# Rezoning Transportation Analysis

Petition Number: 2023-042

**From: Jake Carpenter, PE**  
Jacob.carpenter@charlottenc.gov  
980-221-5675

Revision Log:	Date	Description
	7-26-23	First Review (PM)
	8-23-23	Second Review (PDM)
	11-27-23	Third Review (JP)
	12-20-23	Fourth Review (JP)

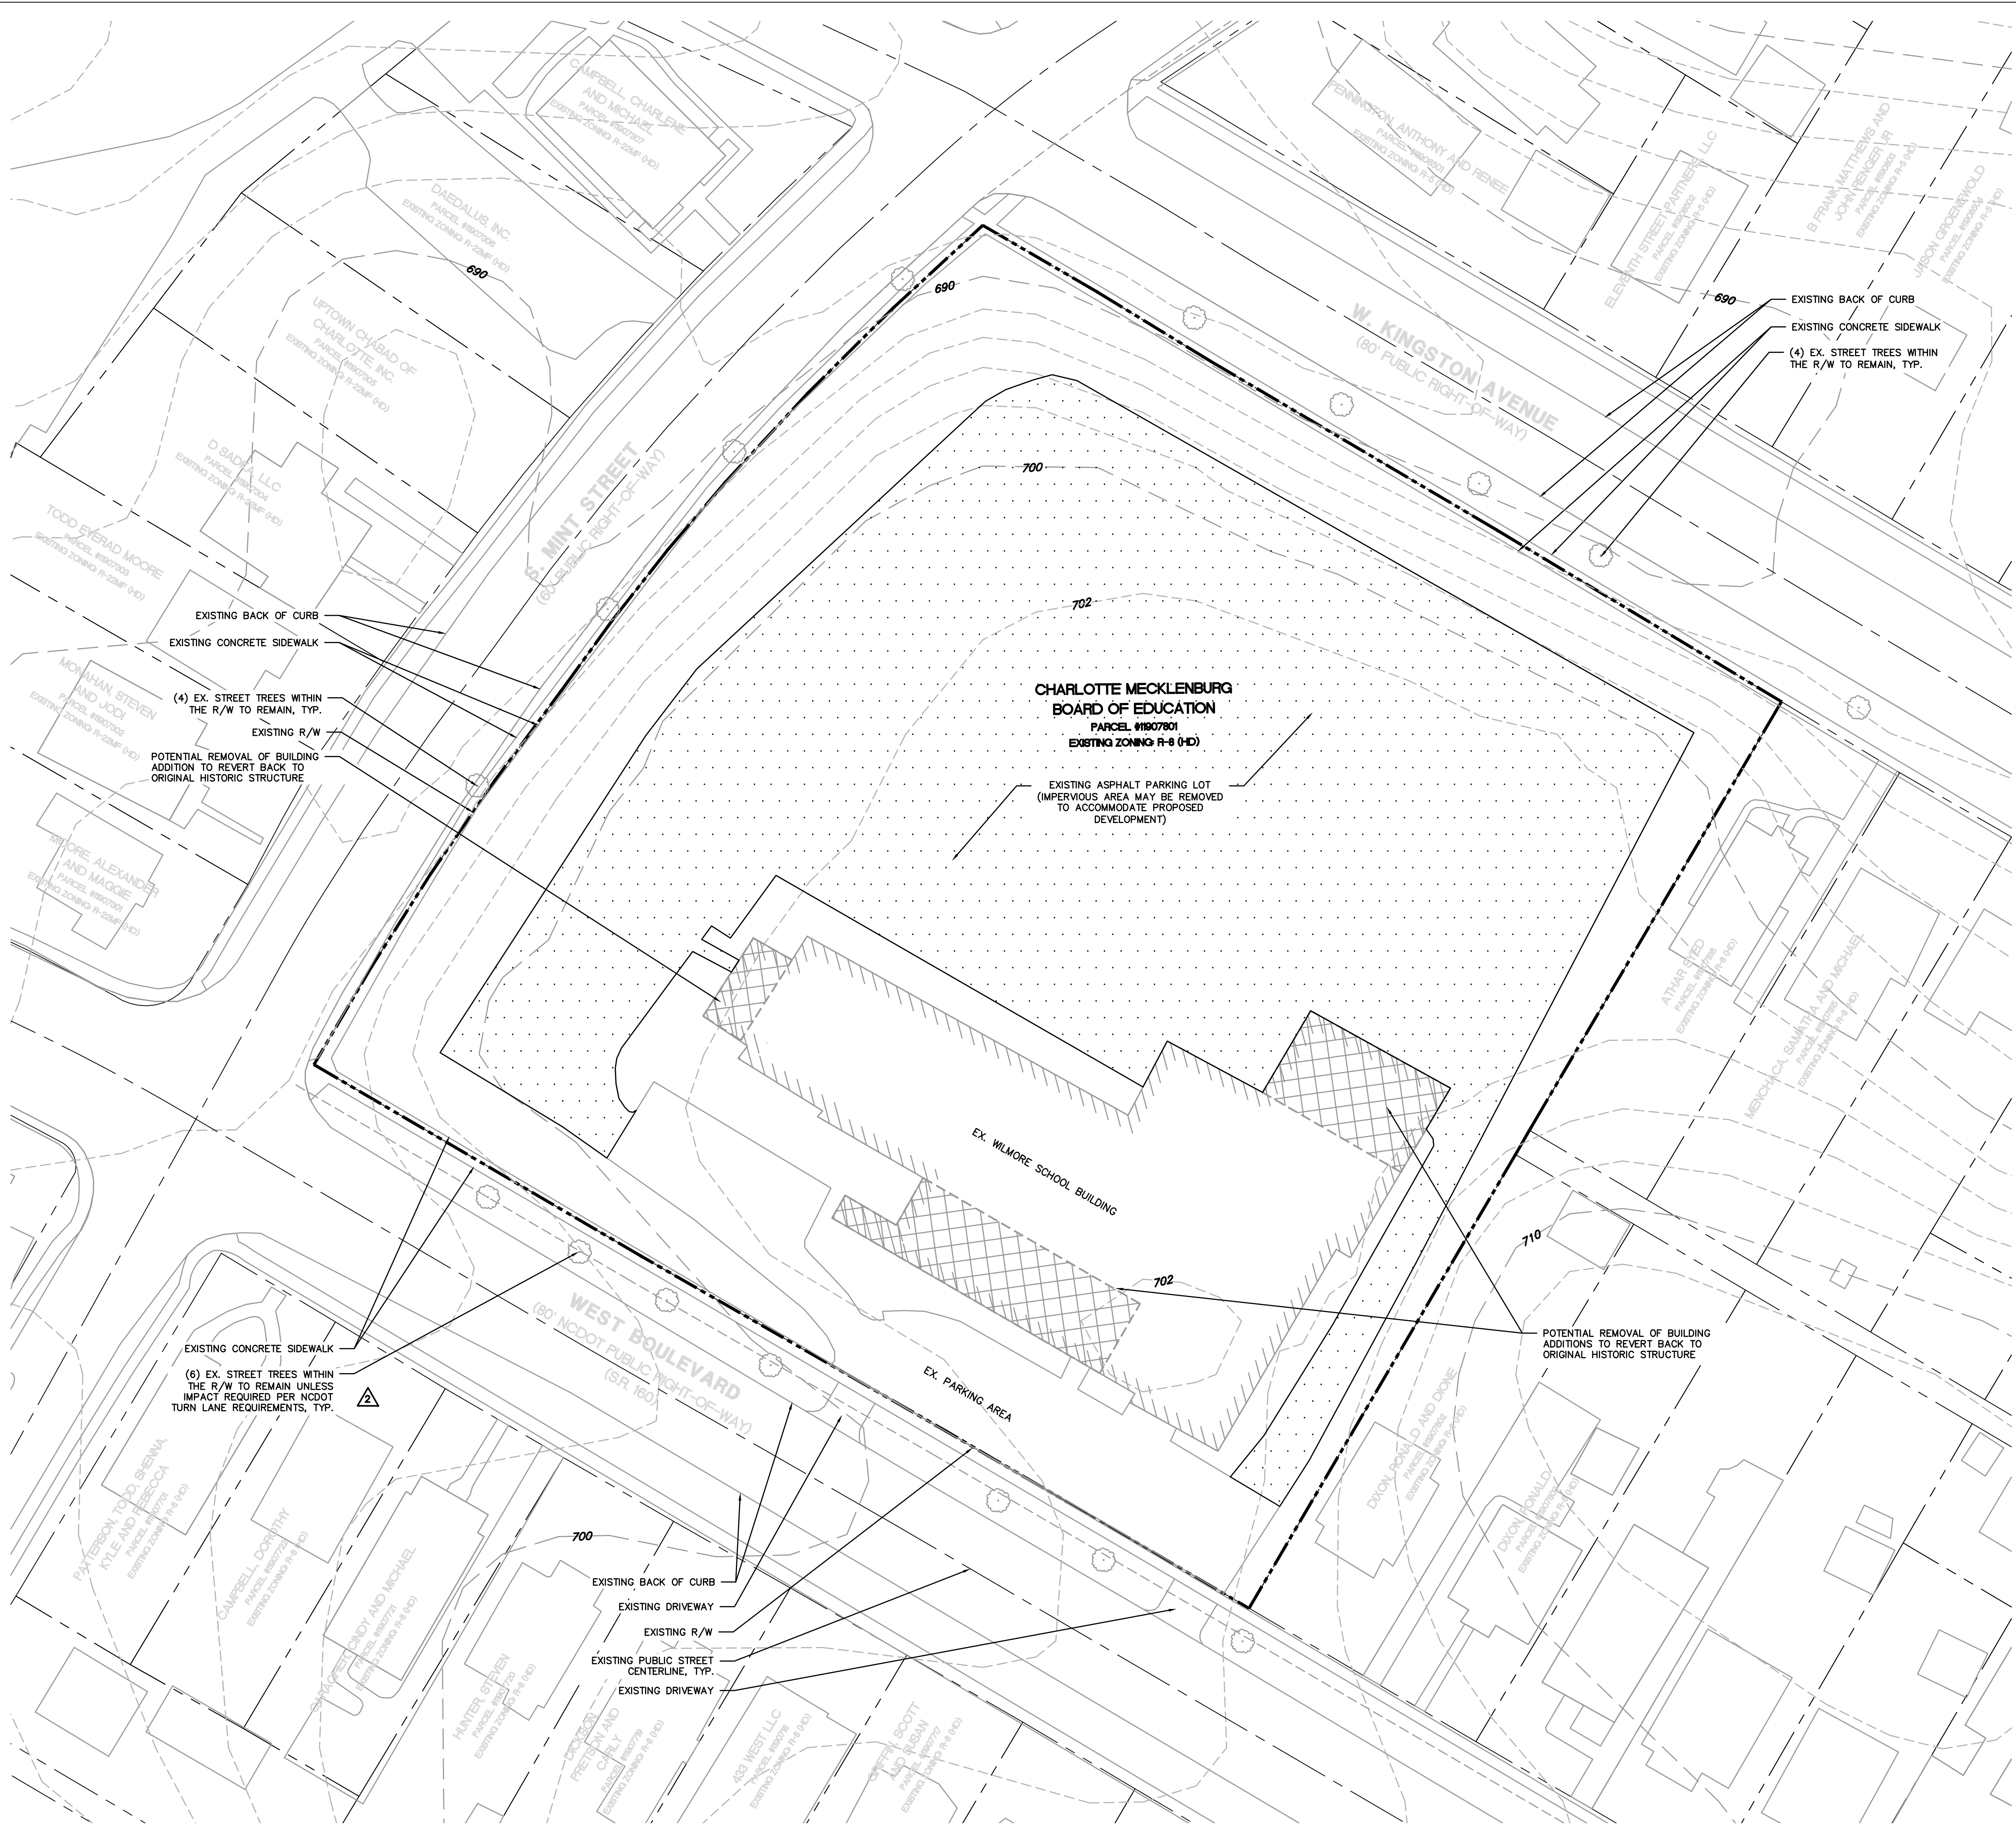
Label and dimension the future curb and gutter location from the centerline for each road on the site plan.

4. **Outstanding Comment from 7.26.23:** In coordination with NCDOT, revise site plan and conditional note(s) to commit to construct bicycle facilities by installing a 12' multi-use path on West Boulevard to meet the Council-adopted Charlotte BIKES Policy. Charlotte Streets Map calls for buffered bike lanes, NCDOT will not allow buffered bike lanes on West Boulevard. Multi-use paths maintained by the City shall meet ADA/PROWAG requirements.

**Clarifying Comment from 11.27.23:** Proposed streetscape is only 8'. Due to NCDOT not wanting a bike lane on their street, this needs to be a 12' shared use path.

**Clarifying Comment from 12.21.23:** Revise proposed streetscape to a 12' multi-use path to support council adopted Charlotte BIKES policy.

5. **Outstanding Comment from 7.26.23:** Revise site plan to install the proposed streetscape off the future back of curb located 30' from the centerline.

7. **Outstanding Comment from 7.26.23:** Per coordination with NCDOT, the site access on West Boulevard needs to be right-in ONLY with a right turn lane.

**Clarifying Comment 11.27.23:** Revise site plan and conditional note to read, "Potential future driveway. Further coordination with NCDOT during permitting."

**Clarifying Comment 12.20.23:** Although this is an existing driveway, NCDOT has the authority to remove or limit access. Add statement to callout and conditional note that approval of West Boulevard driveway will be coordinated during permitting.
